Application No: CM/70/21/PL
Site Address: Land at Wren Cottage Horsemere Green Lane Climping BN17 5QZ
Description of works: Subdivision of the plot and construction of 3 detached bungalows with associated parking, access and landscaping (resubmission of CM/17/21/PL). This application is in CIL Zone 3 and is CIL Liable as new dwellings.

Thank you for your internet representation made on 13th December 2021 which has been recorded as an objection with the comments as follows:

It is acknowledged that alterations have been made to the proposed dwellings with regards number (3 rather than 4) and height (now single storey). However, the Parish Council is not satisfied that their original concerns have been fully addressed as outlined below. Therefore, Climping Parish Council objects to the application for the following reasons:

Title
Location & Block Plan

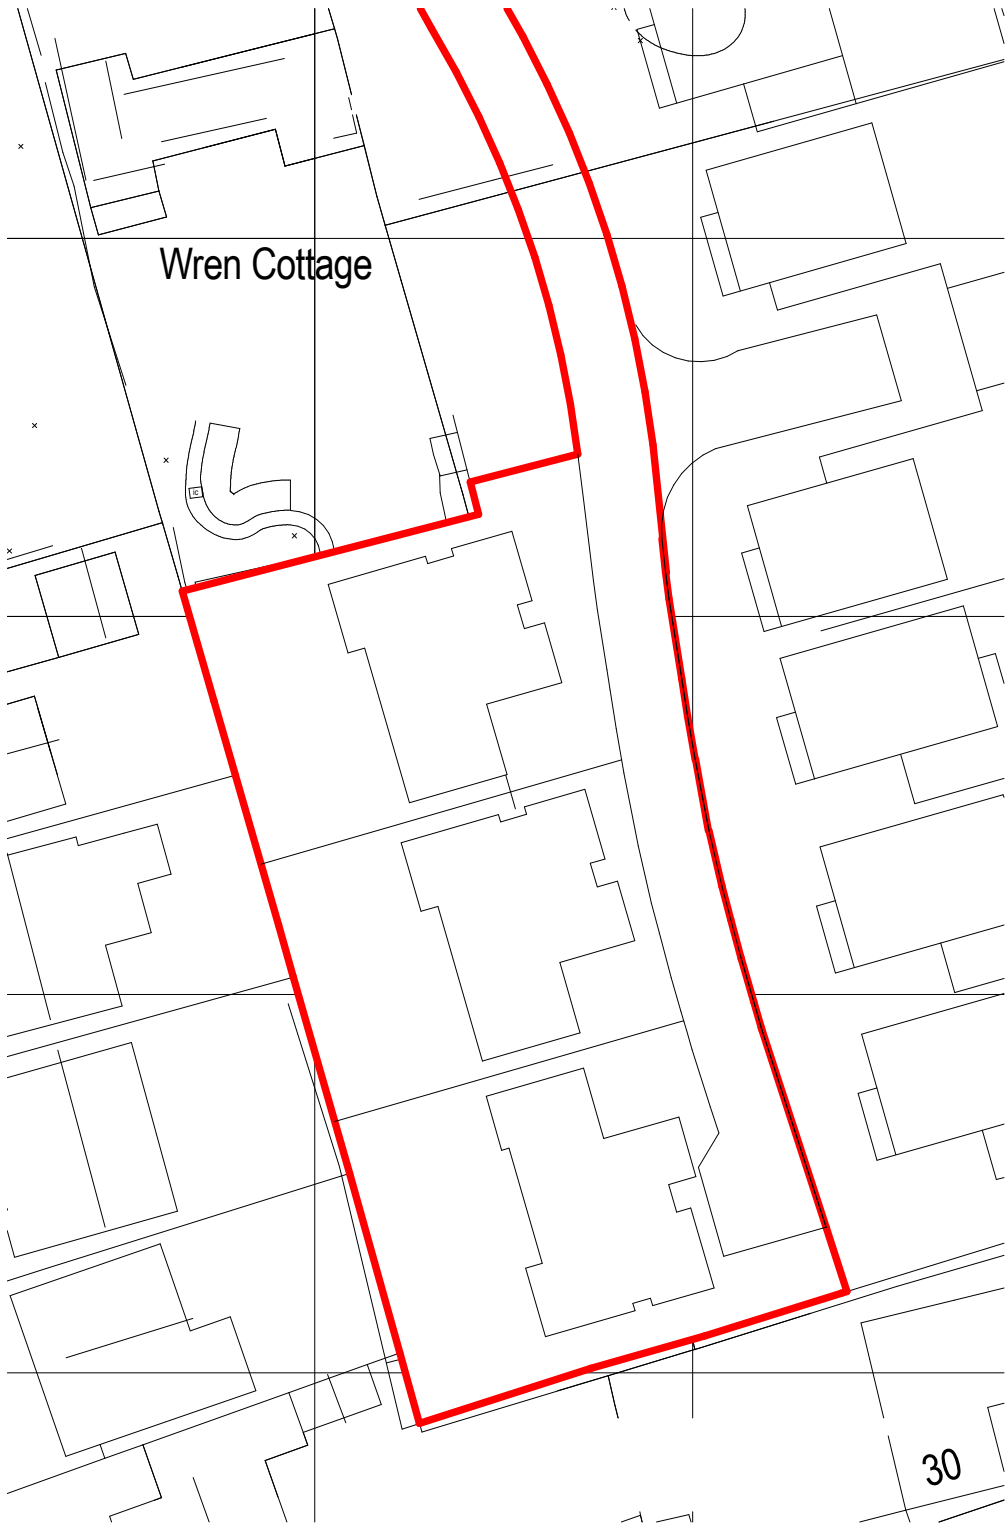
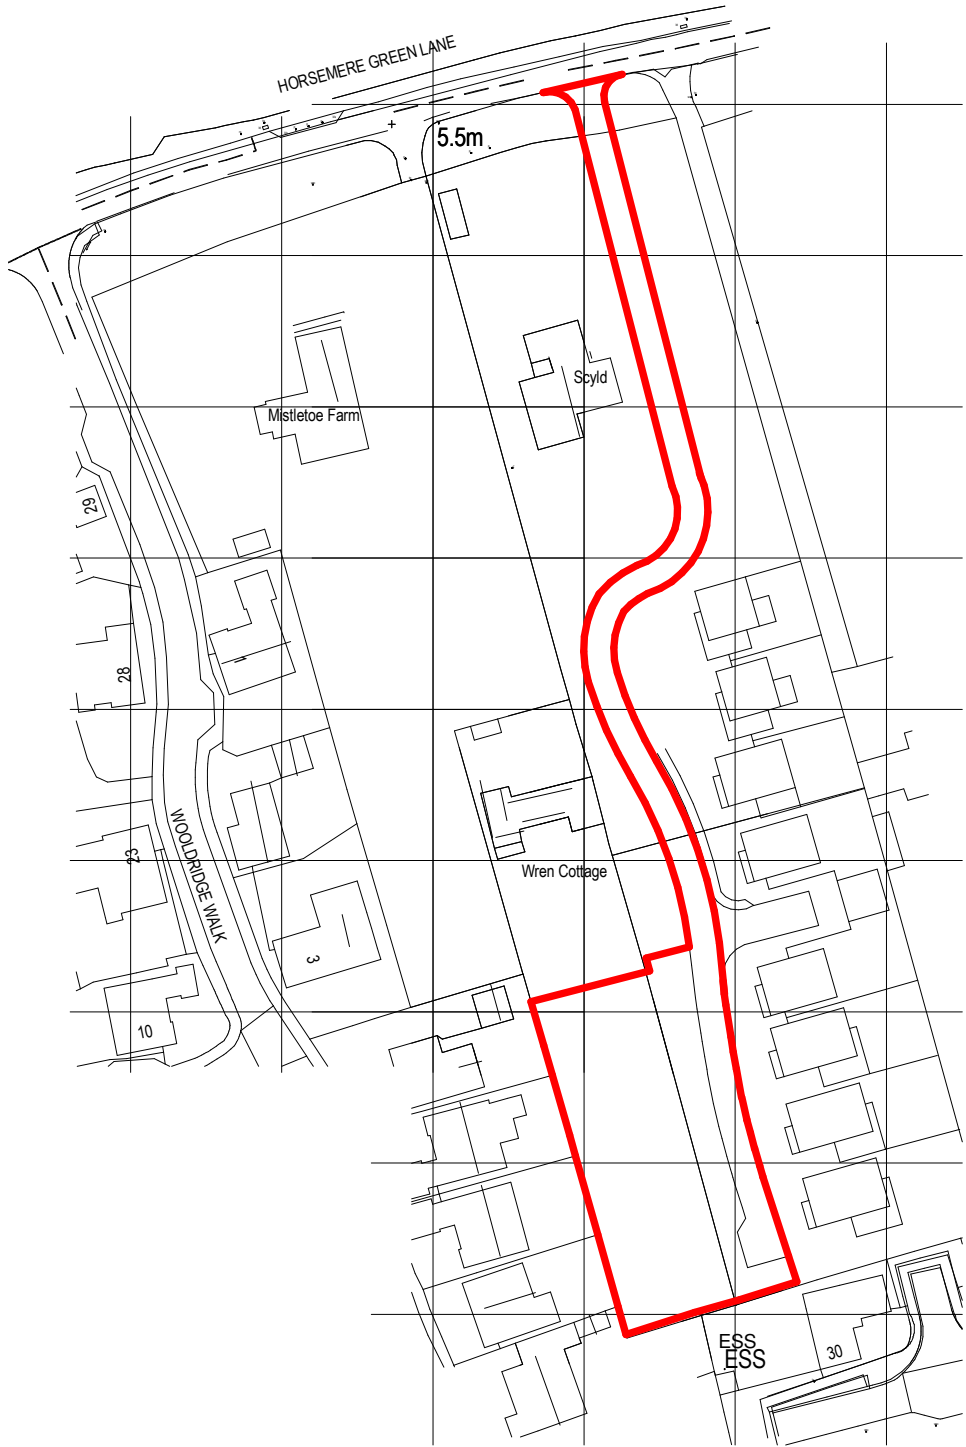
1. There is no provision for amenity space. The development uses the same access as the 9 dwellings approved in application CM/21/19/PL (land adjacent to Scyld) so the access will serve 12 dwellings if this application is approved. If there had been one application for 12 dwellings there would have been a requirement to provide an amenity space/children's play area. Provision of an amenity space should be required in this application in the interest of neighbourhood amenity as the overall development is being extended.

2. Regarding the roads, road layout and parking facilities:
 - There is insufficient visitor parking
 - There is no turning point at the end of the road access to these 4 dwellings and this will create problems for car and delivery/rubbish collection vehicles etc. The turning point halfway in does not address this problem.

- Access is via CM/19/21/PL and onto Horsemere Green Lane. The access junction on to Horsemere Green Lane needs to be re-assessed to allow for 12 dwellings to safely use it.

- This is a further step of overdevelopment along Horsemere Green Lane with no commensurate improvement in facilities for pedestrians, cyclists and those with limited mobility. There is no pavement or footpath provision in this section of the lane.
